Recommendation Report for Planning Permission for Works or Extension to a Dwelling

REF NO: FP/233/20/HH

LOCATION: 9 Wansford Way
Felpham
PO22 7NL

PROPOSAL: Single storey rear extension, first floor side extension and conversion of roofspace to habitable use and dormer.

Proposed North Elevation

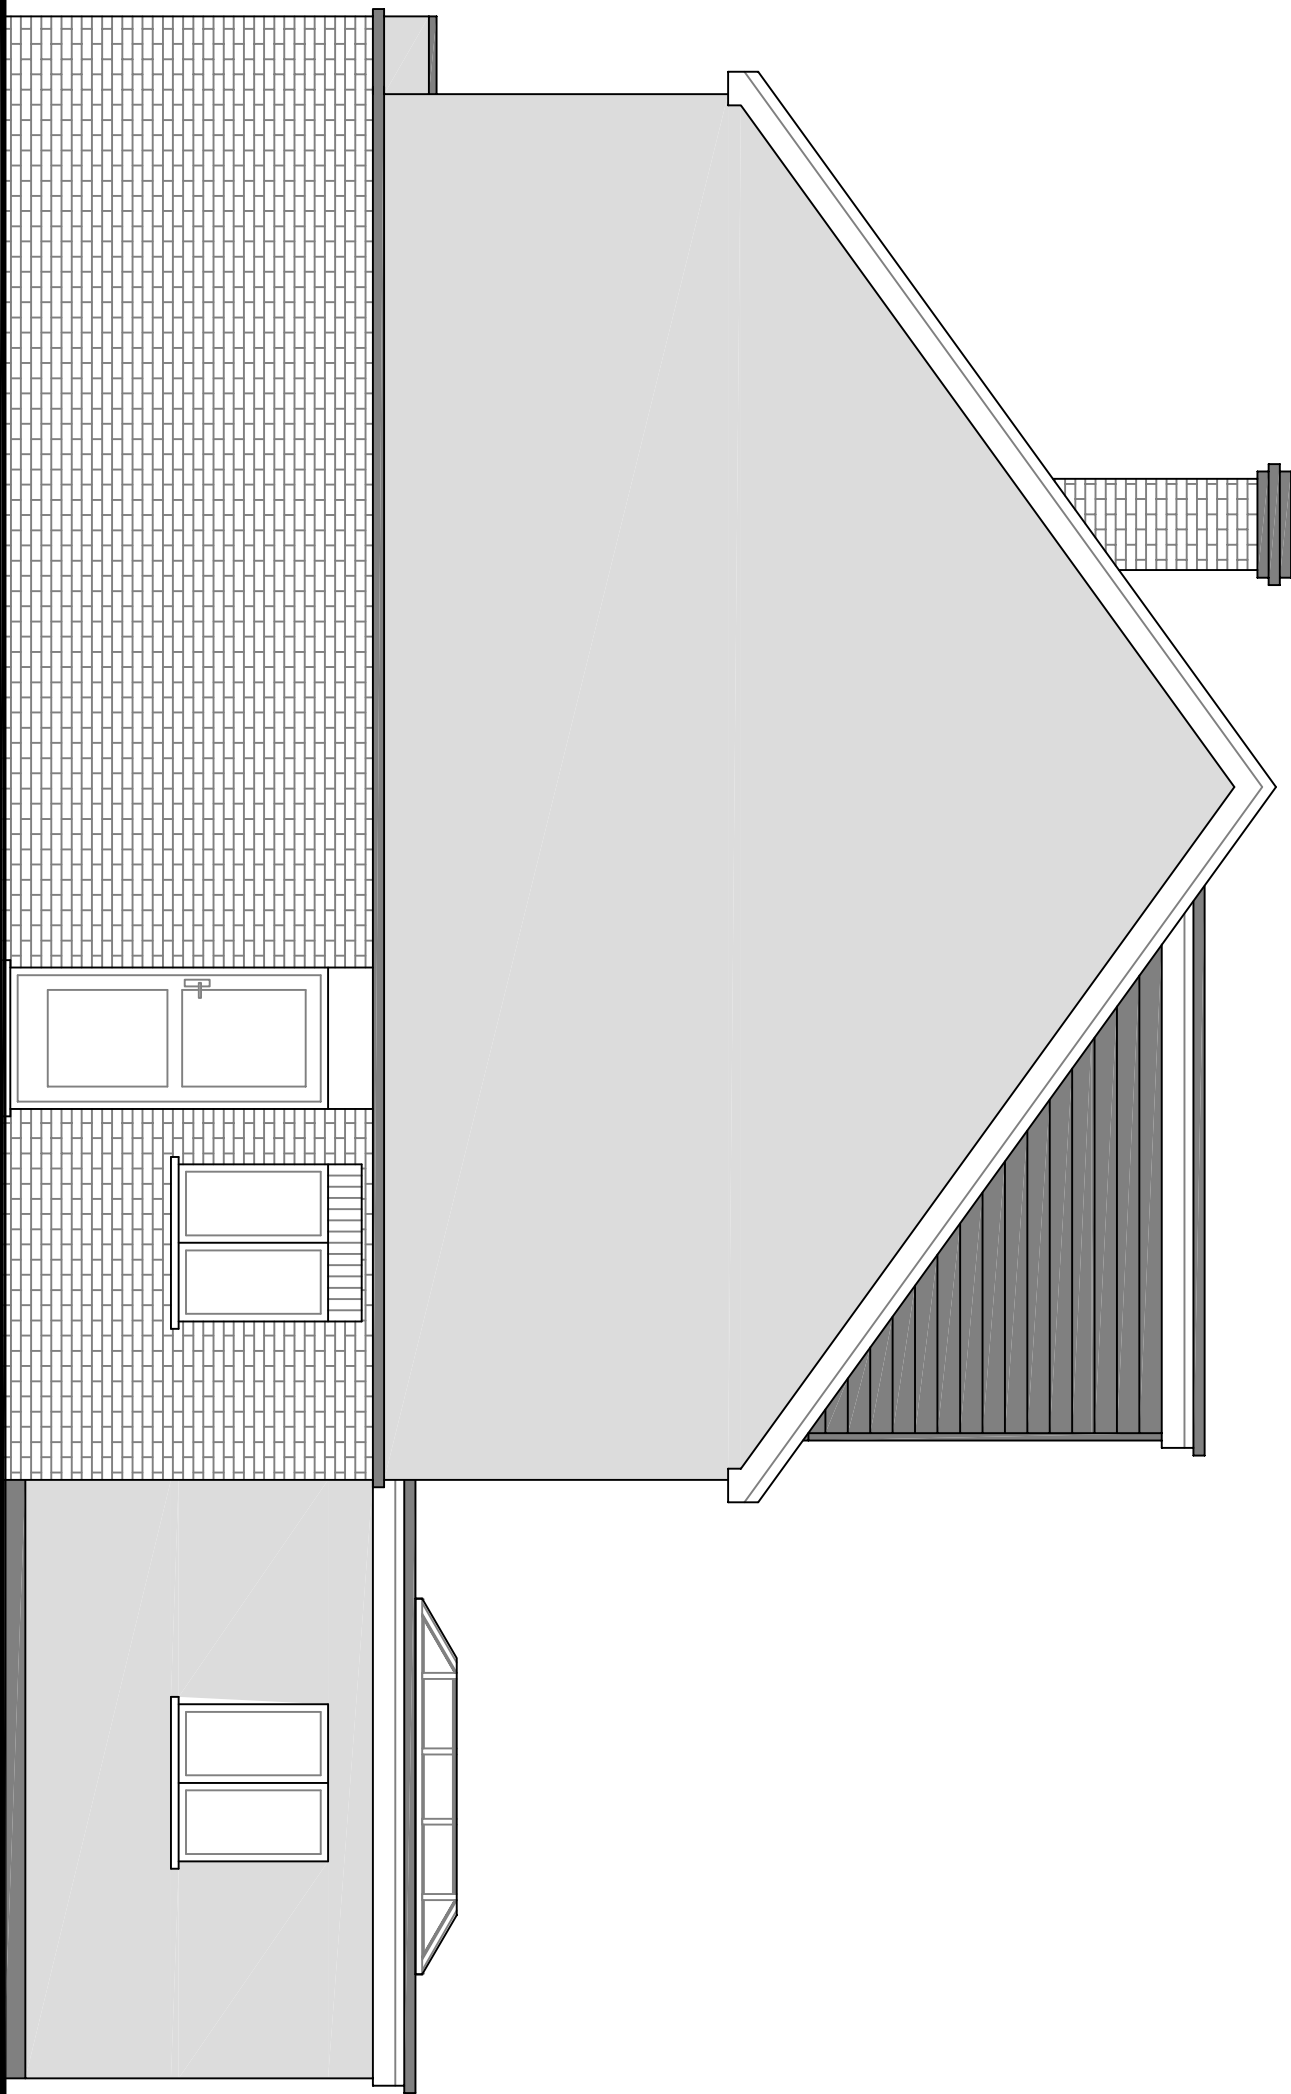
The property has an attached garage to the northern side and a first floor will be constructed above. The roof will extend to encompass the first floor addition and as such it appears well integrated and as a subservient addition.

Over 1m is retained to the boundary from the first floor addition and is not considered to appear an overdevelopment on site.

There will also be a dormer to the rear elevation. This will have a depth of 3.6m and a height of 2.6m and will run along the rear roof slope retaining approximately 1.3m to both sides. This will have a juliet balcony again overlooking the rear. Whilst this will give rise to views that aren't currently achievable, although with no properties directly to the rear, views are not considered significant.
